CITY OF ALBUQUERQUE

July 31, 2018

**RE: Adagio Apartments
Tr A, Cantata at the Trails Unit 2
Conceptual Grading Plan Stamp Date: none (7/19)
Drainage Report Stamp Date: none (7/19)
Hydrology File: C09D014**

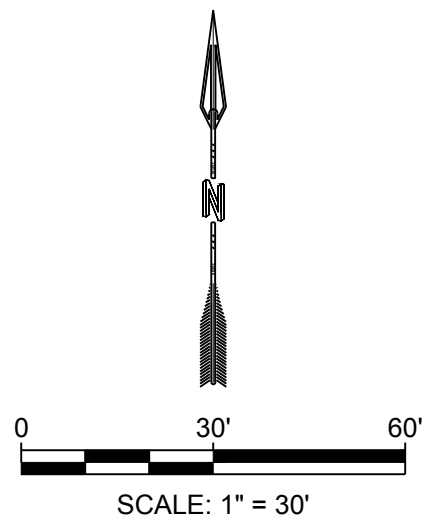
2. Identify all existing drainage easements on the plan, as well as any proposed easements, vacations, and lot line adjustments.

3. Identify all drainage infrastructure as private vs. public.

4. Include project benchmark and datum.

13. Drainage conveyance for basins 2-4 is questionable. Will these basins actually make it to the drive aisles? If so how? Can you add low points or drain lines for the sidewalks, along with swales? You could also treat these areas as contiguous self-ponding areas, coupled with drainage covenants. This would also enable basin 1 to free discharge.

- d. Pond routing as necessary.
15. A waterblock, 0.87' high, per COA Paving Detail No. 2426, is required at the driveway entrance.

SHEET NUMBER:	<b>C-102</b>	
SUBMITTED FOR:	DRB SITE PLAN	
SHEET TITLE:	<b>CONCEPT DRAINAGE PLAN</b>	
PROJECT NAME:	<b>ADAGIO APARTMENTS</b>

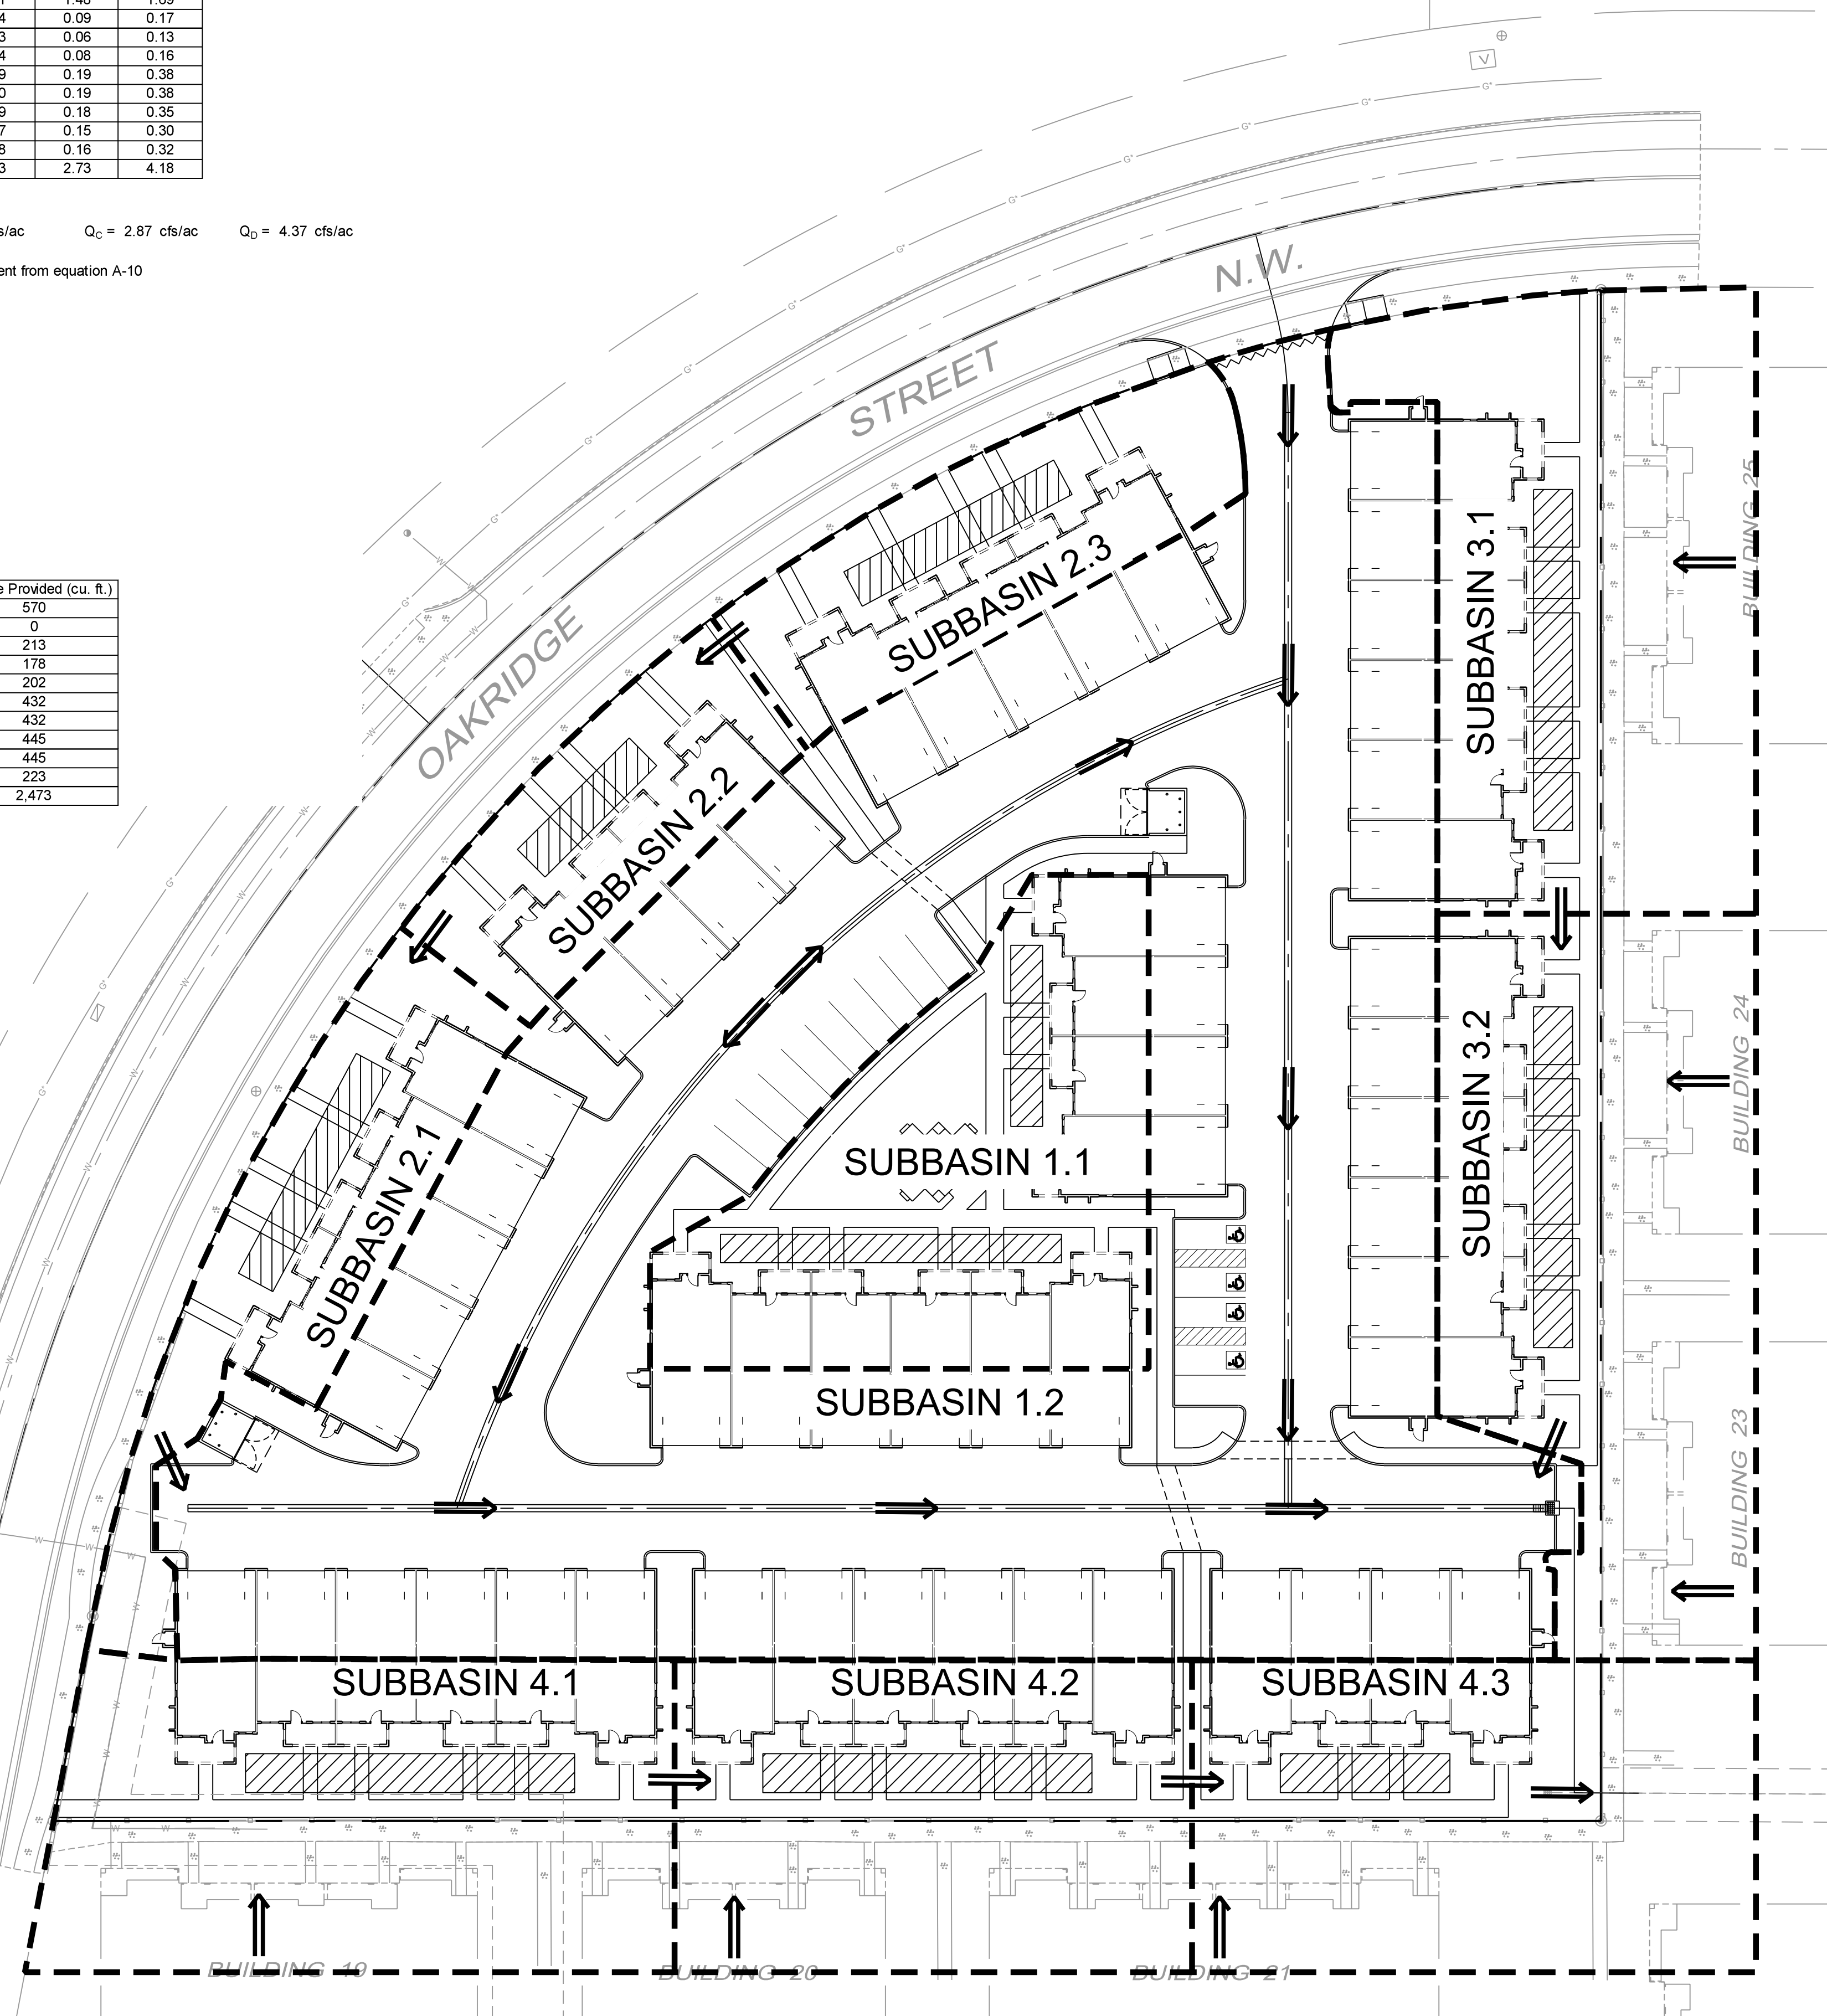
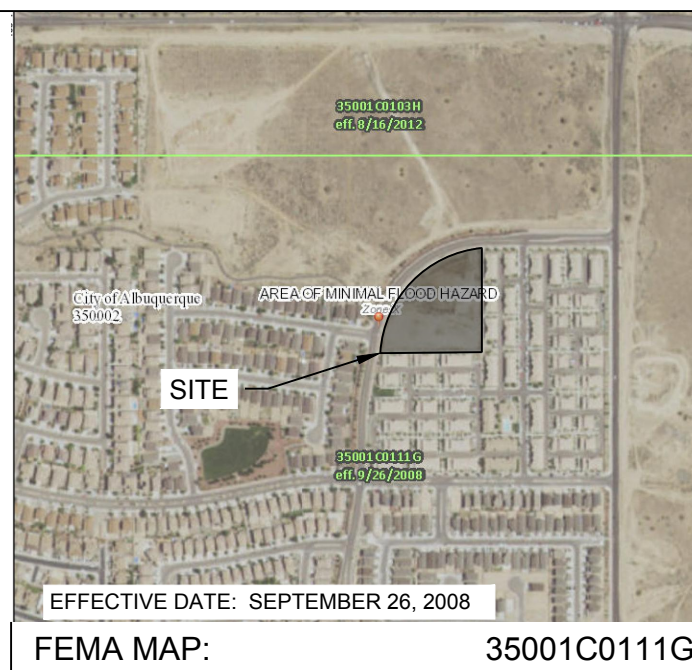
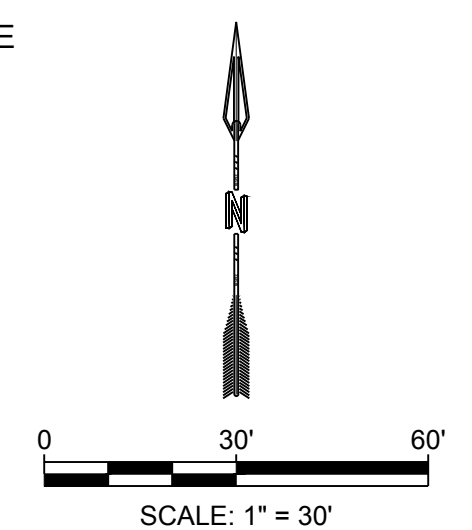
8. Provide one (or several large) central facility for Stormwater Quality volume (SWQV) retention; individual ponds for each apartment unit will not be accepted.

9. Please provide the SWQV calculations for each basin draining to each pond. The stormwater quality ponds need to be sized for the areas draining to them.

10. Please show and label the pond(s) and include a label on each with the SWQV and elevation, the 100-year volume and elevation, the peak 100 year inflow and outflow, the spillway crest elevation, and the spillway flow depth.

11. The site must demonstrate adequate downstream capacity per § 14-5-2-12(G) of the Albuquerque Code of Ordinances. 10 cfs discharge to the storm drain is identified, but how will runoff be controlled?... pond, orifice plate, detention in the drive aisles? The controlling feature needs to be identified and designed.

12. This site must also comply with the approved drainage master plan (Thompson, 2015) for the Trails. The proposed plan seems to be generally consistent, but this needs to be investigated and discussed.
